Our Ref: F2016/00155 – D02830544

21 December 2016

**Subject: Notification of UNSW Biological Science project SSD6674 MOD1**

Fig. 5 - Proposed Amended Building Form (Aerial view from northwest)

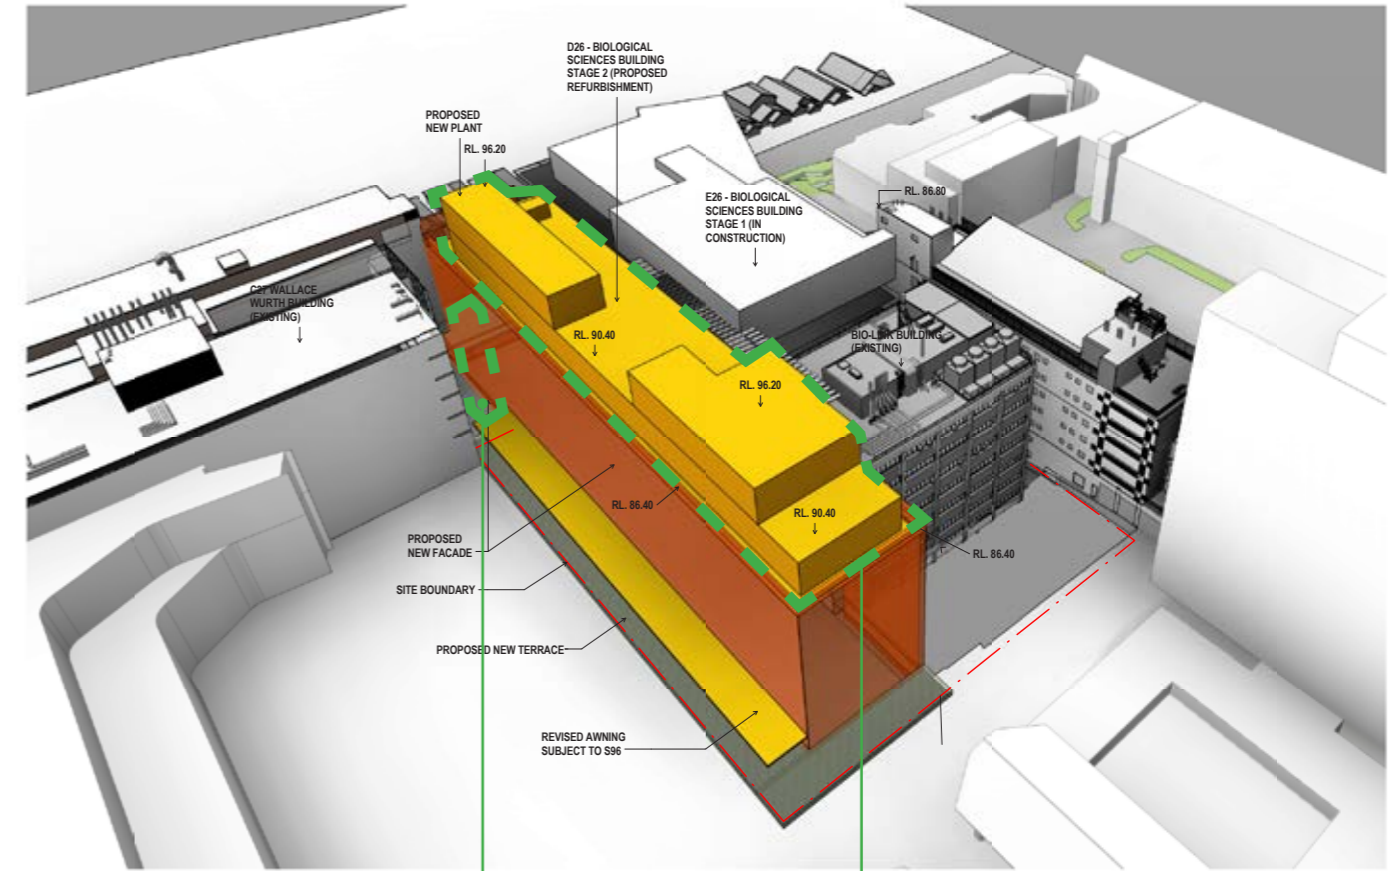
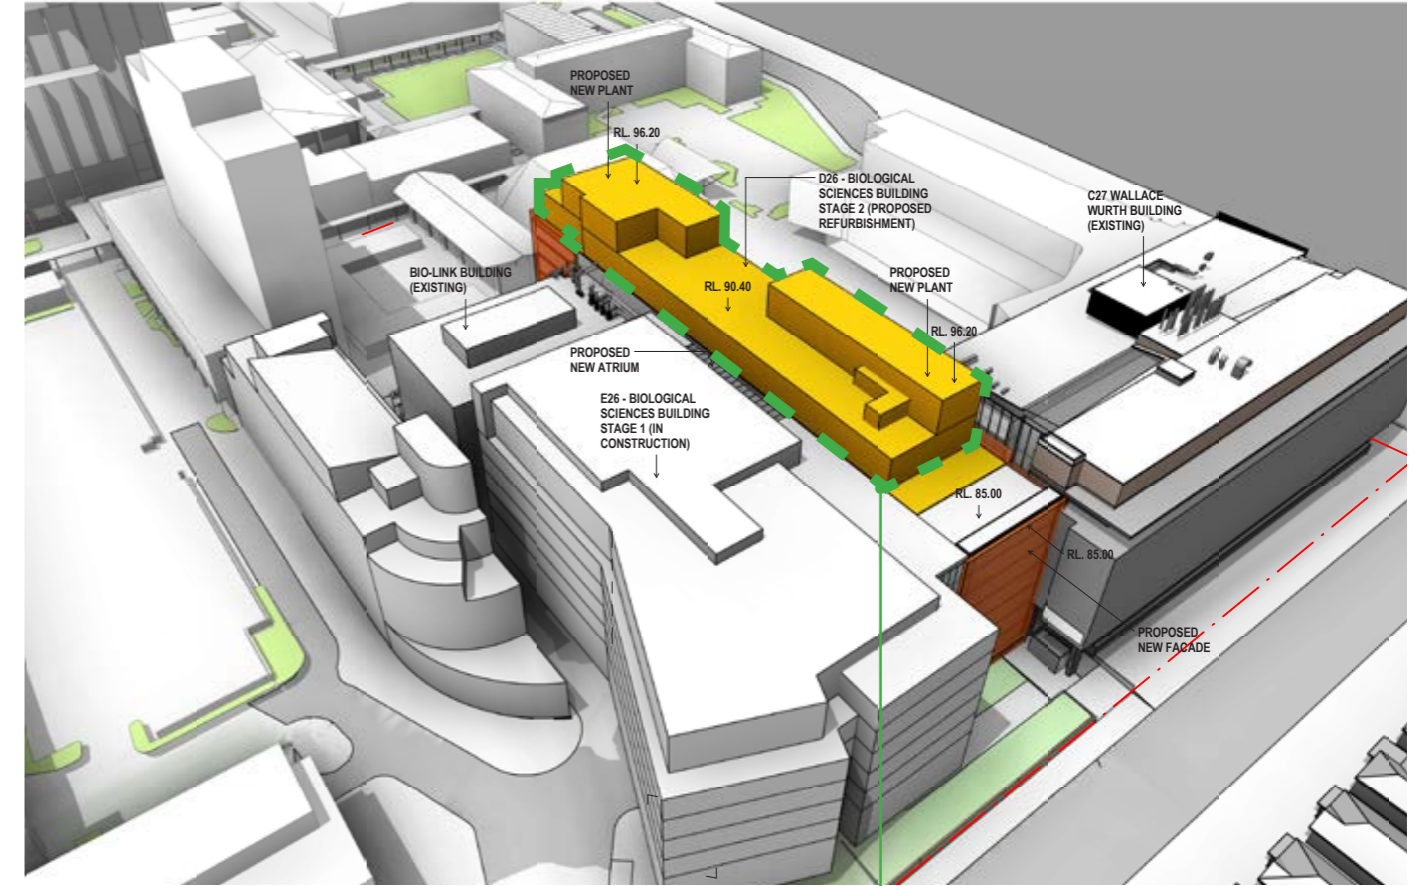
The inclusion of additional plant level to building D26 further exceeds the maximum building height standard under the RLEP 2012 resulting in screening 6.1m higher than the approved screening of roof plant and the adjoining Biological sciences building to the south (E26) and 5.08m higher than the Wallace Wurth building (C27) to the north.

Although the additional height is setback from the Botany Street frontage and buffered somewhat by the built form of the adjoining buildings on either side, it will still be intrusive when viewed from the public domain. Therefore, it is suggested that an innovative design solution be investigated that would improve its aesthetic appearance and achieve a satisfactory outcome having regard to the key objectives that seek to ensure development contributes to the streetscape character under Section 4.2.6 Buildings in Part E2 of the RDCP 2013.

Fig. 23 - Proposed S96 Amended East Elevation

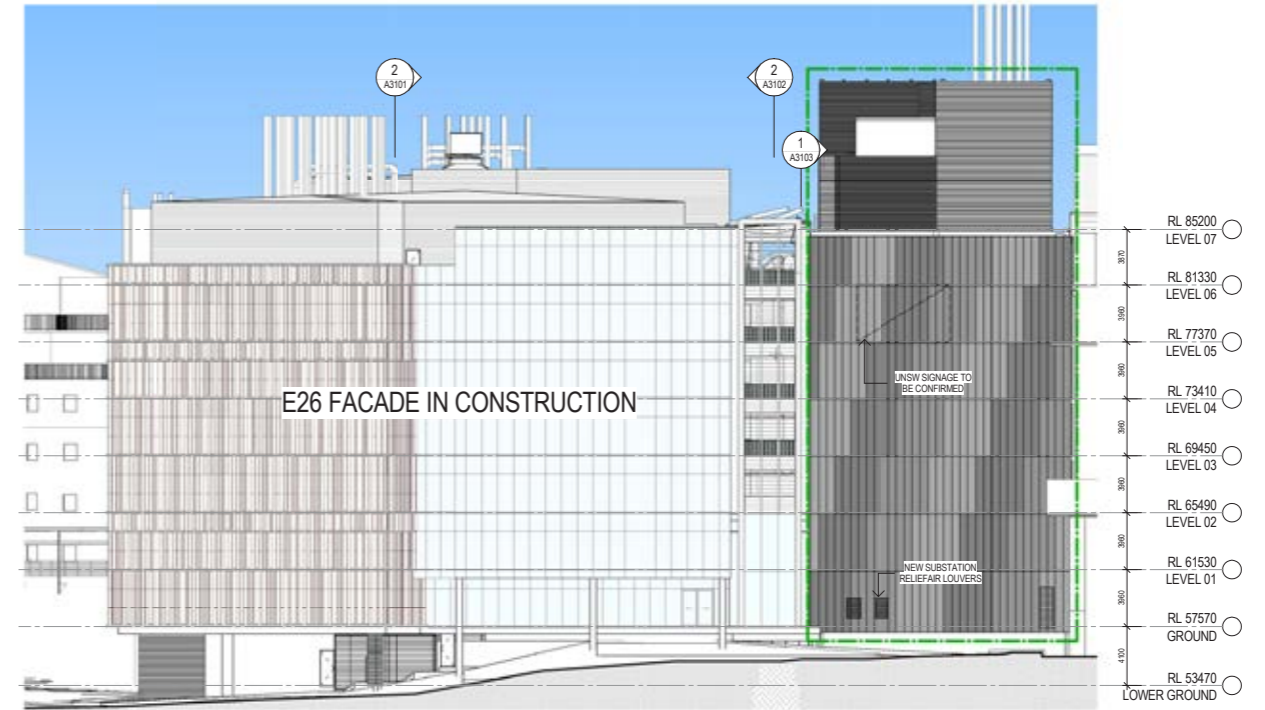
The revised façade treatment to Building D26 along the eastern elevation contributes to the presentation of the building along Botany Street.

Figure 7 – Existing and proposed ground floor plan
Source: Woods Bagot + JBA

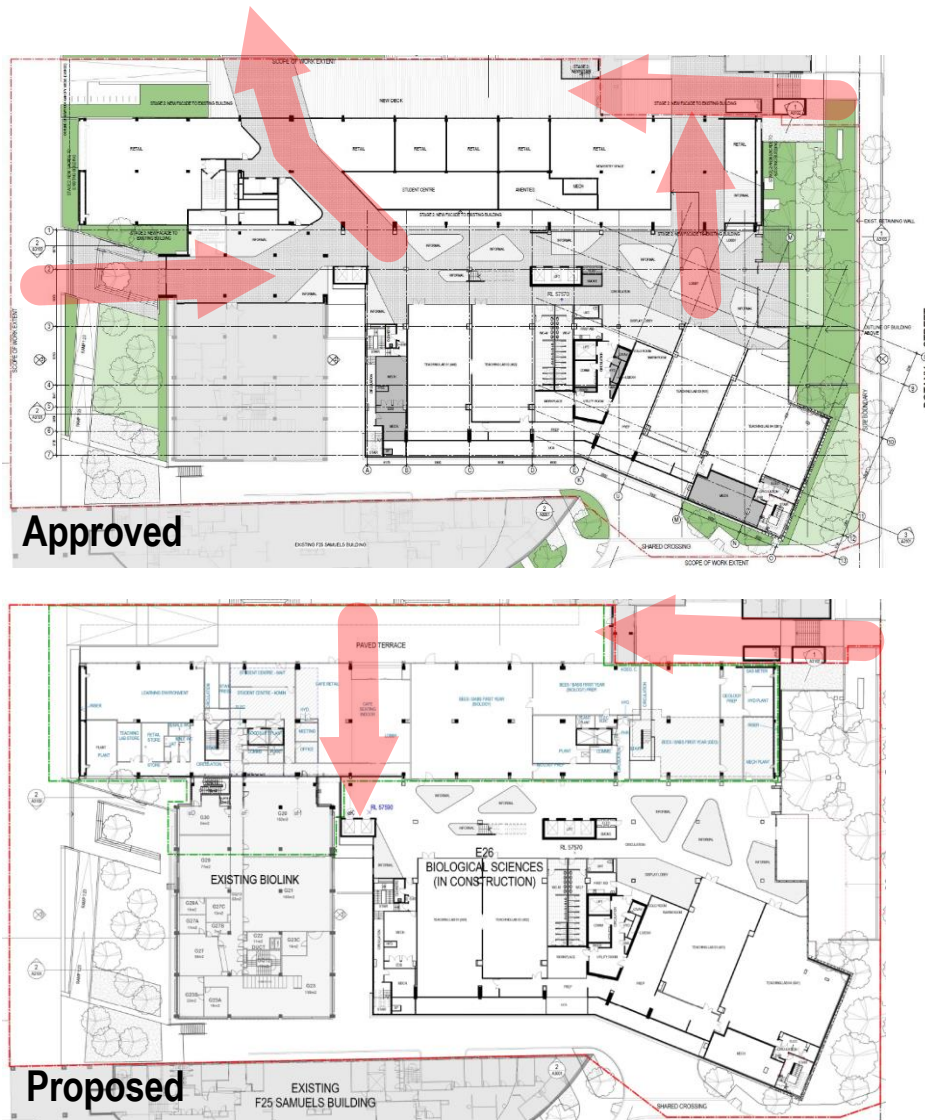
The loss of retail spaces at ground level associated with the revised ground floor layout may reduce the connection with the adjacent knowledge cluster and hub; however the proposal still retains a café at ground level which will retain a diversity of use that will contribute to social interaction with the hub at the north western corner of the building. Although the proposed modifications reduce the retail components at ground level the modification will continue to meet the objective in Section 4.2.4 Knowledge Cluster and Hubs in Part E2 of the Randwick Comprehensive Development Control Plan (RDCP) 2013.

Figure 8 – Tree removal plan
Source: Birds Tree Consultancy

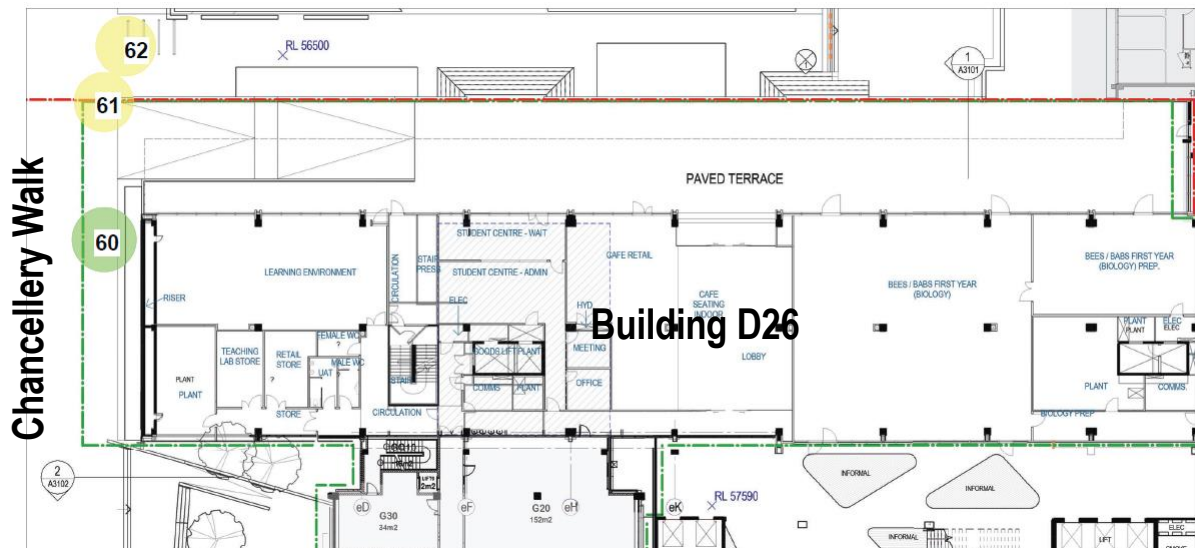
Councils Landscape Officer recommends that the two *Livistona australis* (Cabbage Palms, T60-61) identified in the revised Arborists Report by Birds Tree Consultancy, are to be transplanted to an alternative location elsewhere within the site, into undisturbed deep soil, and are to be incorporated into the building and landscape works as site features.

A detailed written Transplanting Report from a level V consulting Arborist (who must also be a registered member of a nationally recognized organization/association), must be submitted to, and be approved by, the PCA, and must document all aspects of the process, with all requirements of the approved Transplanting Report to be complied with.
